Subject: Your Reference NC2/3/2016/0193 (Contact Stephen Kilmartin) Our reference PA2630

Land East of Chipping Lane, Longridge.

We have considered the above planning application submitted on 7/3/16 and find it could have an impact on our infrastructure.

SITE SURVEY.

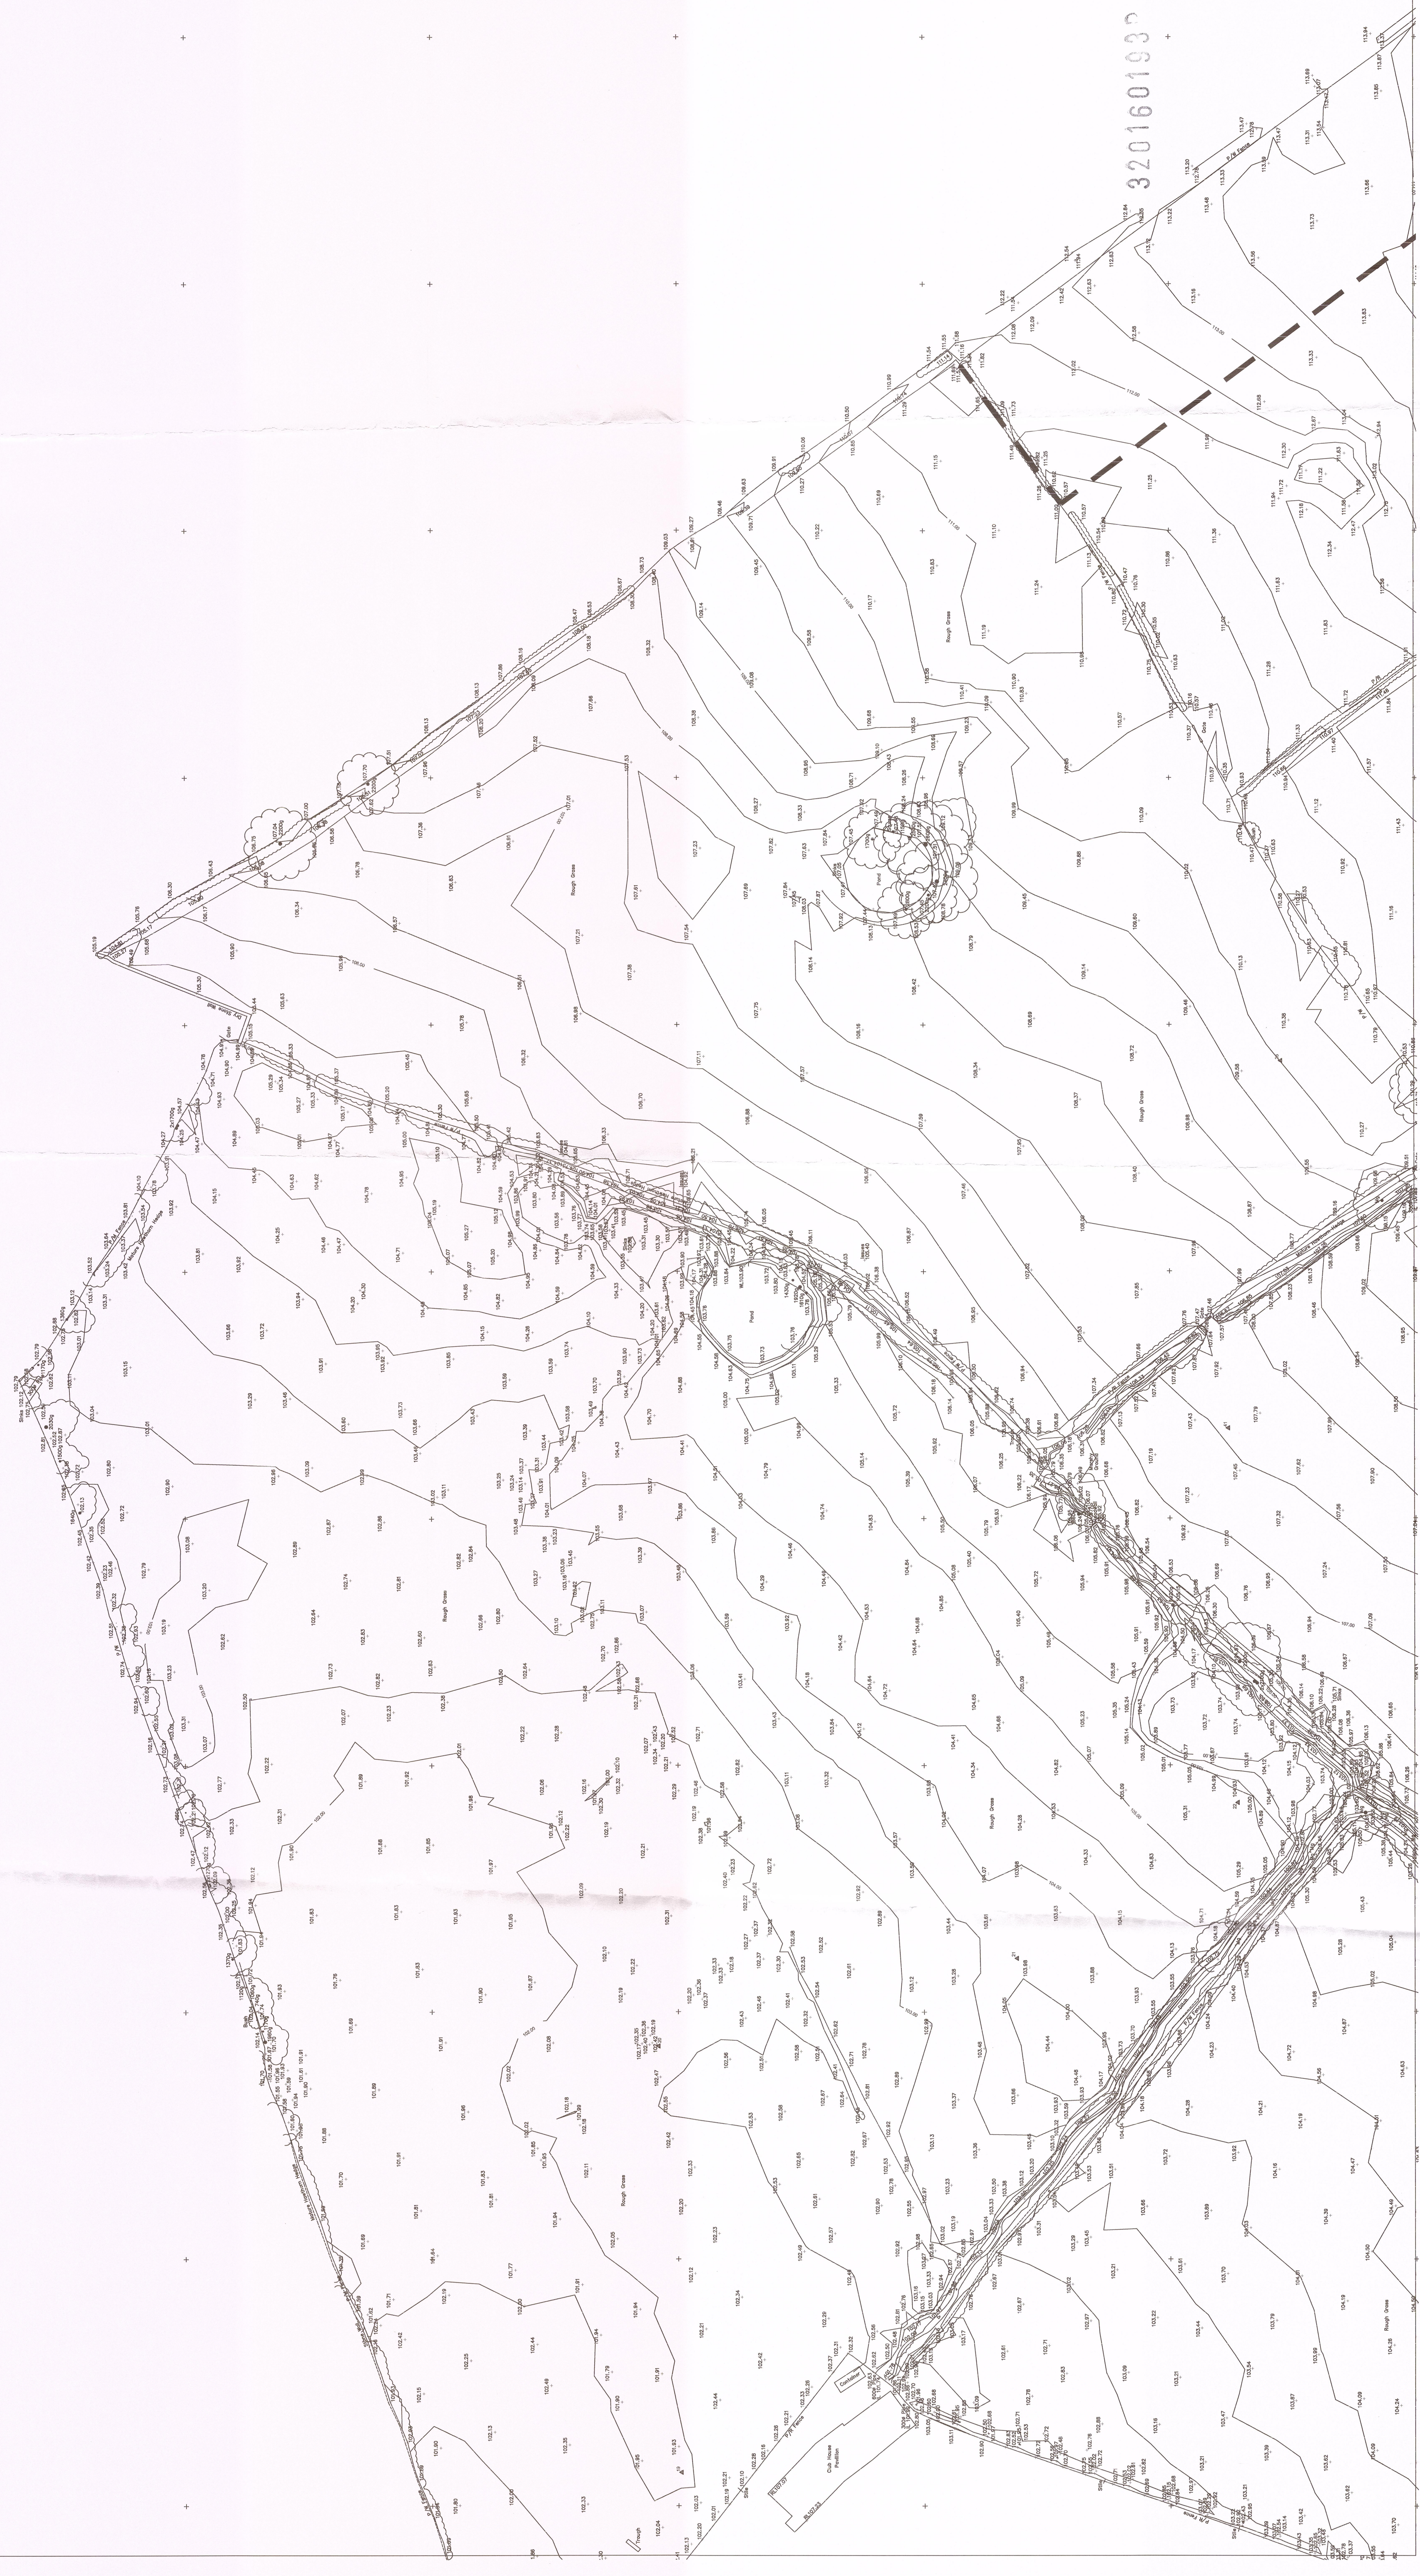
- There is behind 62 Inglewhite Road, within the development area, an LV Underground cable which feeds an Overhead service to the existing Cricket Club. The cable will have to be cut and Bottle Ended at the source and the OHL removed from site to allow the development to take place.
